# V1 - Legal Description - RLR.pdf Markup Summary

REZONE MAP  
MULLET SUBDIVISION NO. 1

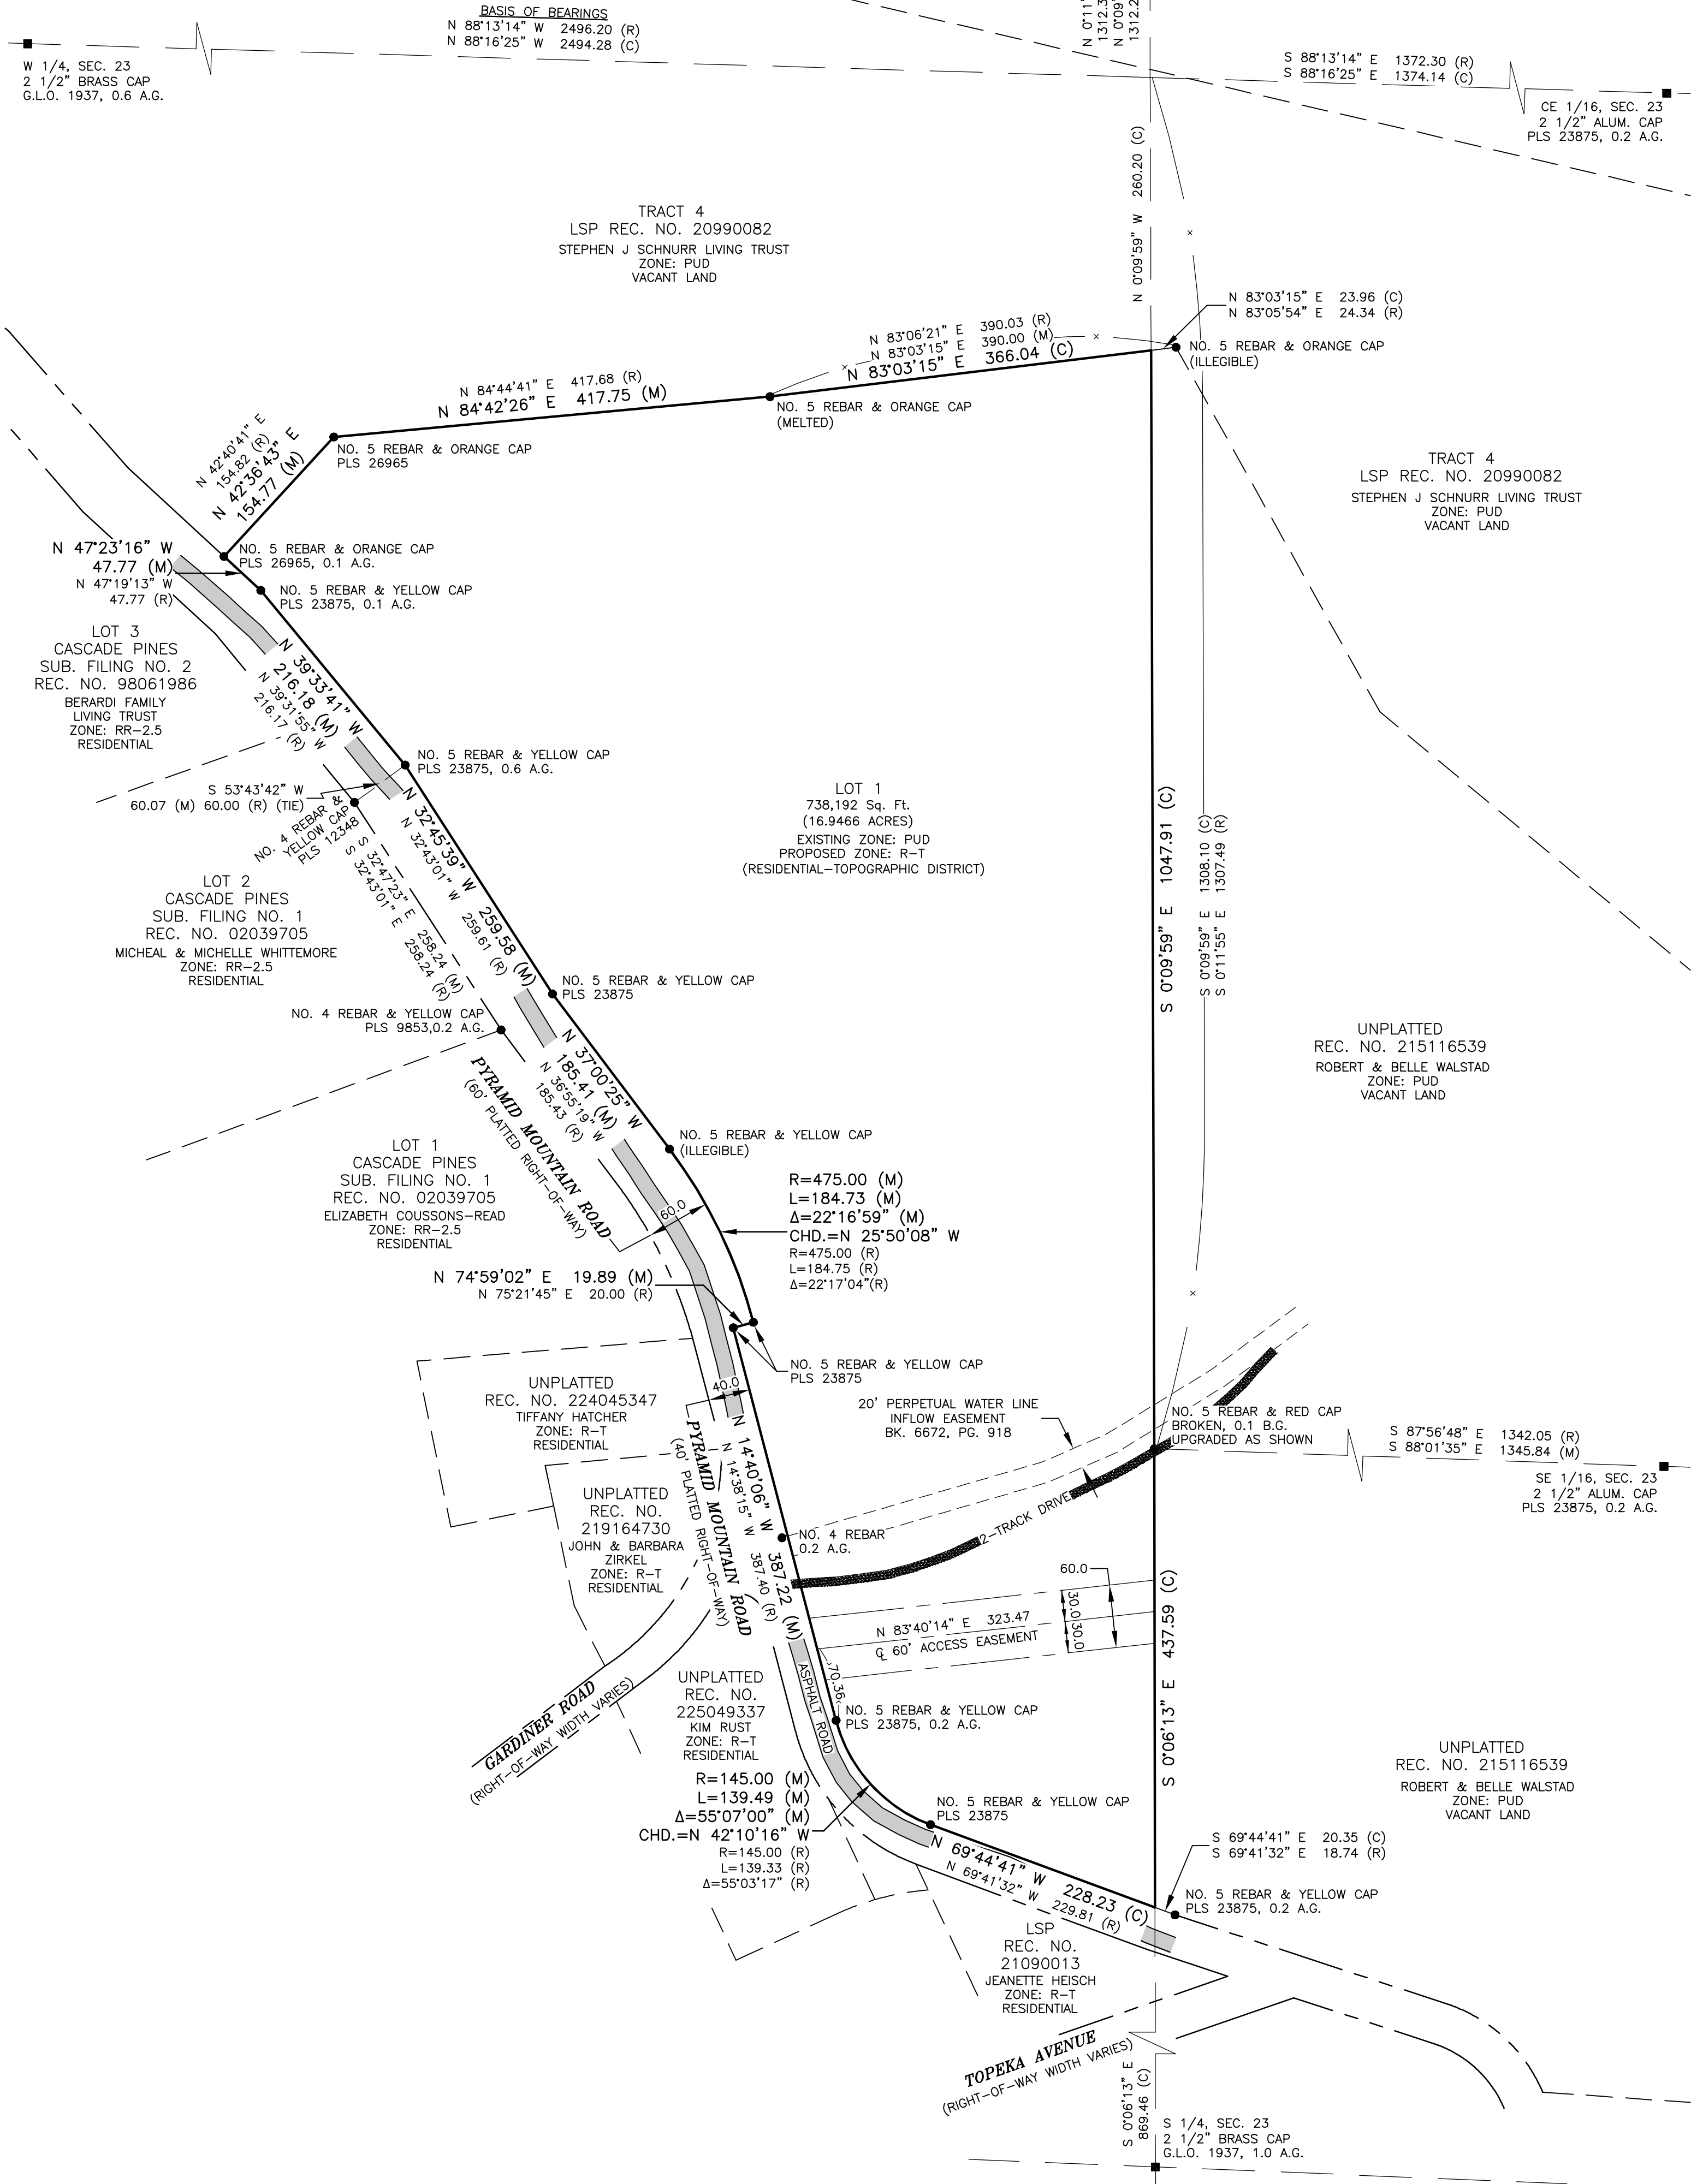
Add: PCD File No. P259

Provide a  
clean copy

This does not match the legal description shown by the Assessor's Office. Please explain the discrepancy.

THE ASSESSORS HAS "TR IN E2SW4 SEC 23-13-68 LY NELY OF PYRAMID MTN RD LY SLY OF TR CONV BY REC #210114997". THE ASSESSORS OFFICE DOES NOT GIVE A FULL LEGAL DESCRIPTION AND IS NOT TO BE RELIED ON AS A LEGAL DESCRIPTION.

THE LEGAL DESCRIPTION AS SHOWN IS FROM THE RECORDED SPECIAL WARRANTY DEED AT REC. NO. 212116539 AND STATING TRACT 4 DESCRIBED IN WARRANTY DEED AT REC. NO. 210114996.

THE LEGAL DESCRIPTION HAS BEEN UPDATED TO INCLUDE "PARCEL A AS DESCRIBED IN SPECIAL WARRANTY DEED AT REC. NO. 212116539...."
